Re: Response to CGS Review Comments
Flying Horse North Filing No. 9
El Paso, Colorado
Entech Job No. 260456
PCD No. PUDSP263

Colorado Geological Survey, review comments dated July 21, 2026. CGS Unique No. EP-26-0092_1 Flying Horse North Filing No. 9. El Paso File No. PUDSP263.

We understand that Filing No. 9 will consist of 11 single-family residential lots. Entech identifies areas that will impose geologic constraints, including (page 1) “potentially expansive soils, potentially seasonal shallow groundwater areas, and the potential for elevated Radon.” The preliminary plan includes a Geologic Hazard Note that includes the following geologic constraints: artificial fill, expansive soil, potentially seasonal high groundwater, slope stability and landslide susceptibility, shallow bedrock, and radon, which were discussed in Entech’s report. Entech’s characterization of the geologic hazards and constraints associated with the site is valid. We offer the following comments:

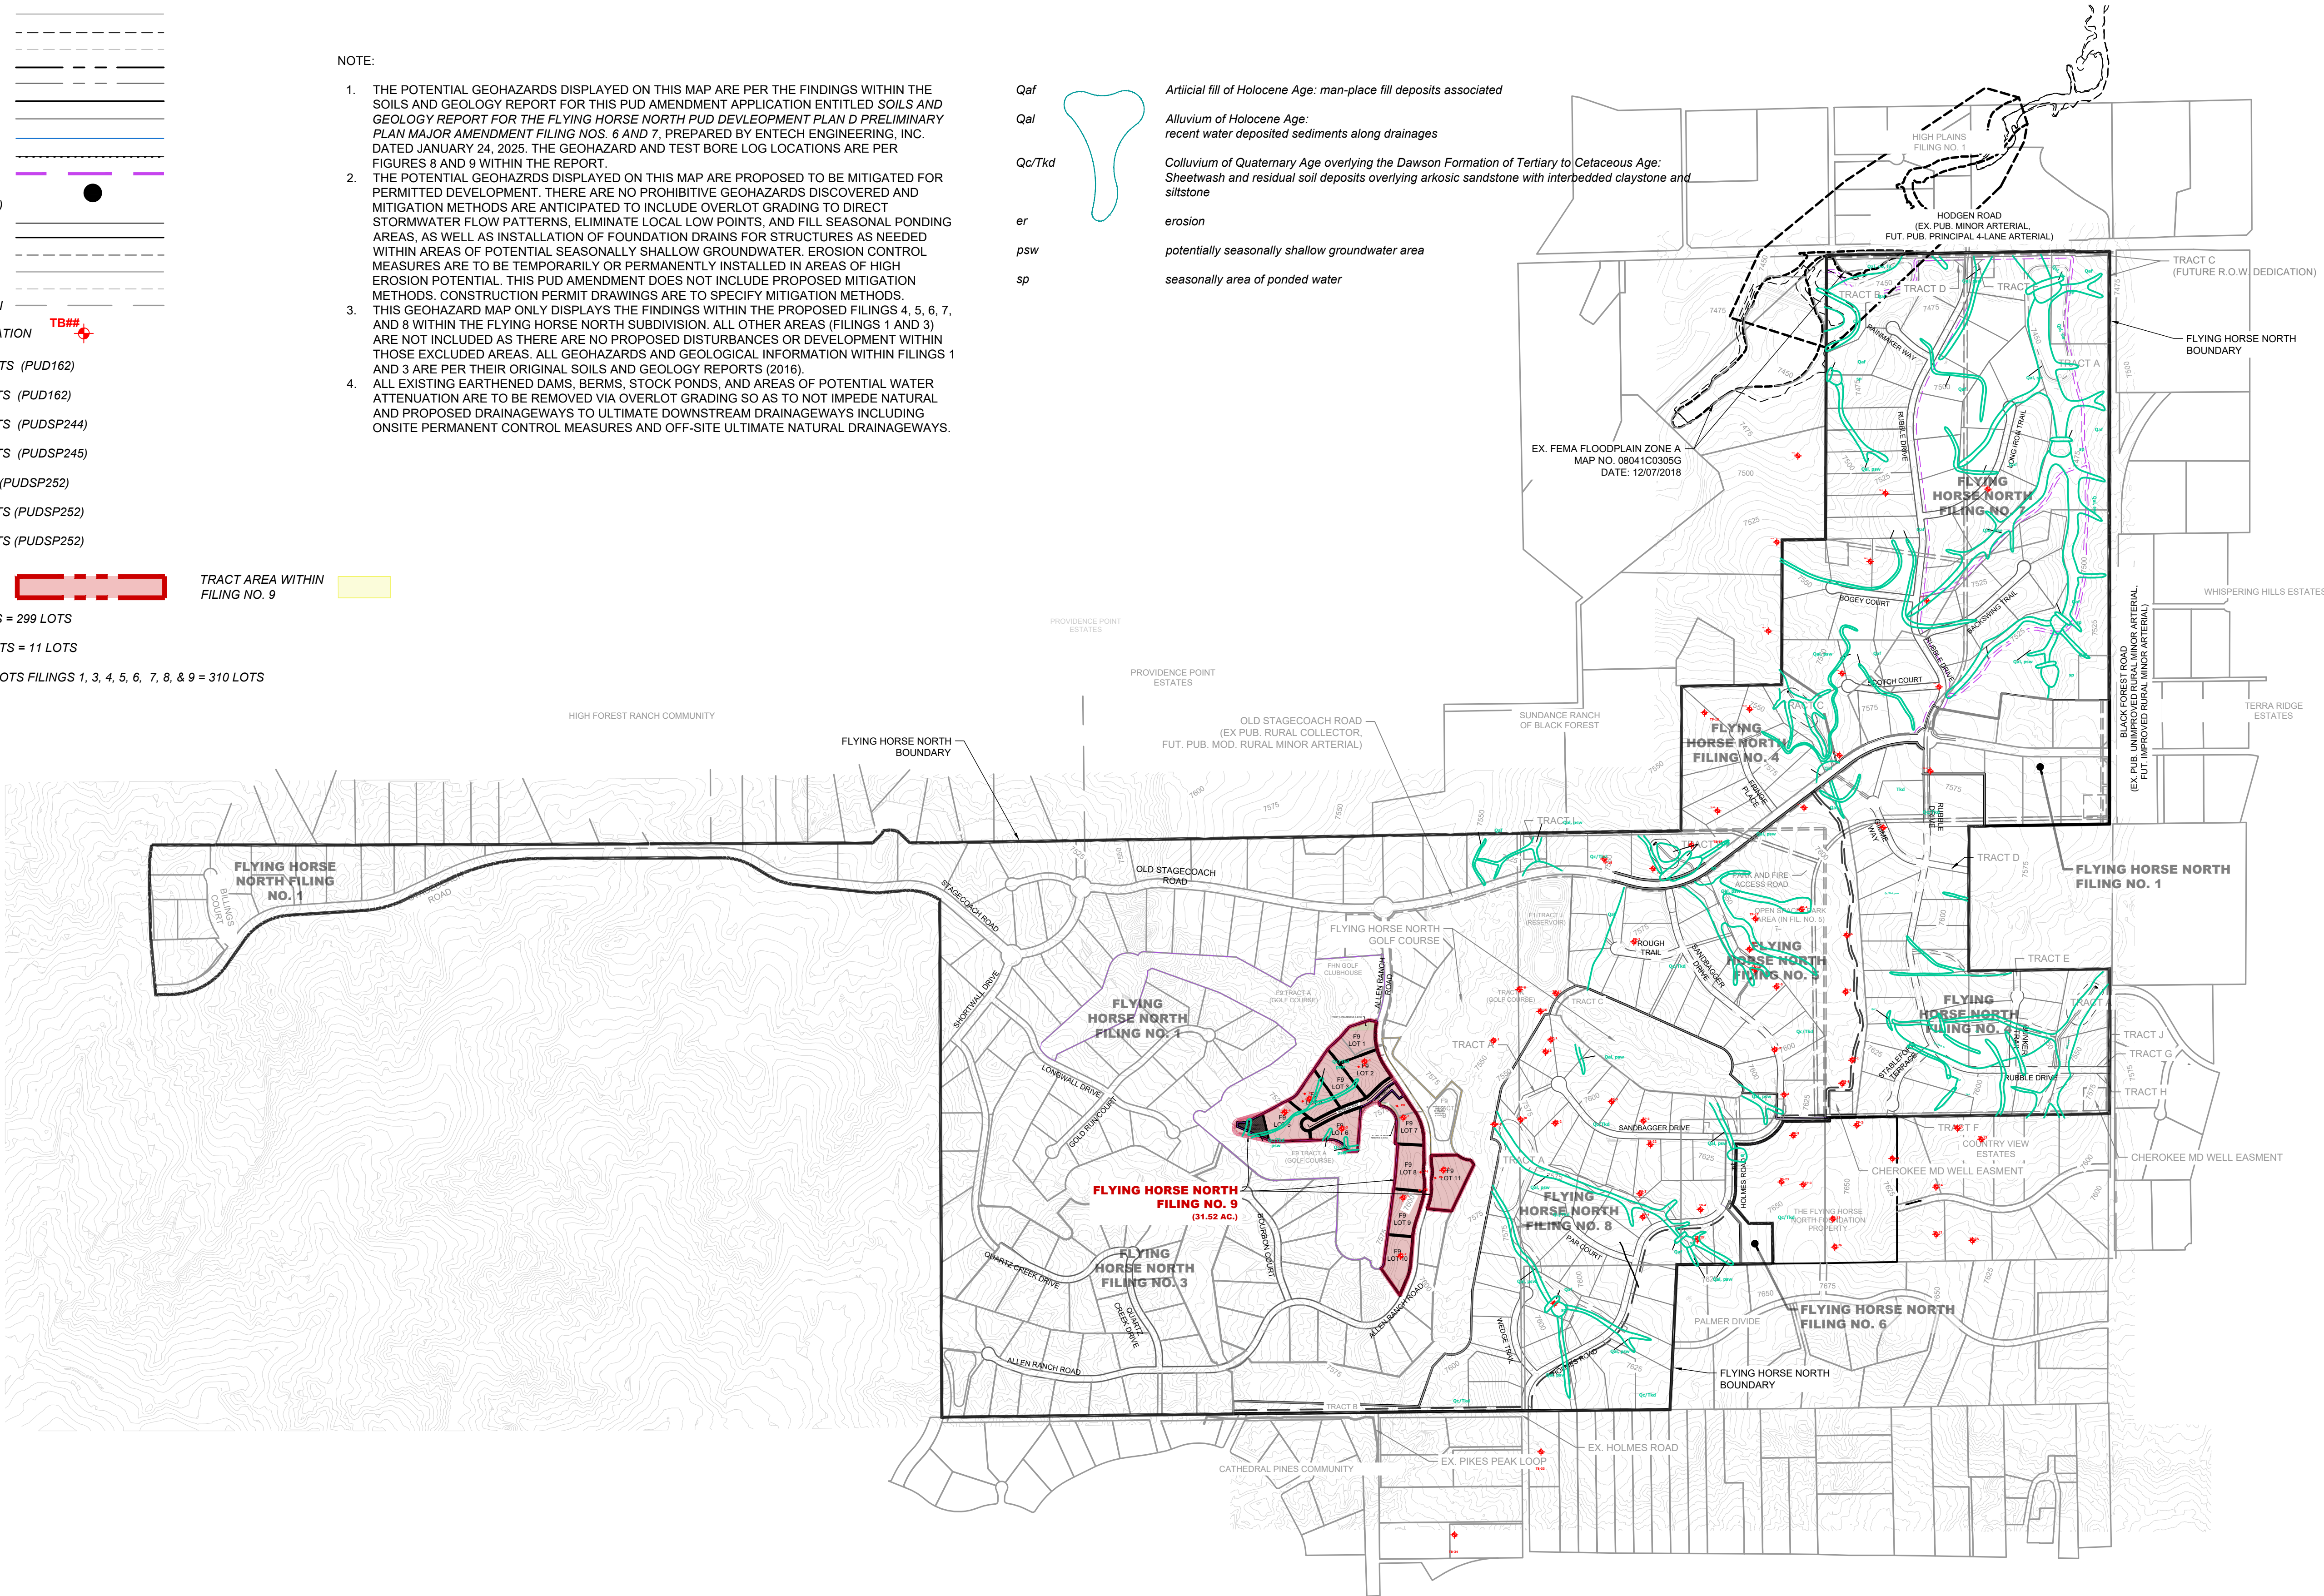
3. Multiple drainages exist within the project area. According to Entech’s study (Fig. 6), these drainages are identified as potential seasonally shallow groundwater areas (psw). The lots affected by these drainages include Lots 2-6 and Pond A. CGS recommends that erosional setbacks be established near drainages and noted in the plans. Building footprints should be outside the setback areas.

Entech Response Comment 3: Entech agrees that setbacks from large drainages should be provided on the plans. It is our understanding that the drainages align with the "psw" areas mapped by Entech. Figure 6 from the Soils and Geology report is attached with this response. Individual lot investigations should also discuss setbacks as warranted. The individual lot investigations should be based on site plans with house location and any site grading to be completed. Minor drainages can be redirected around structures.
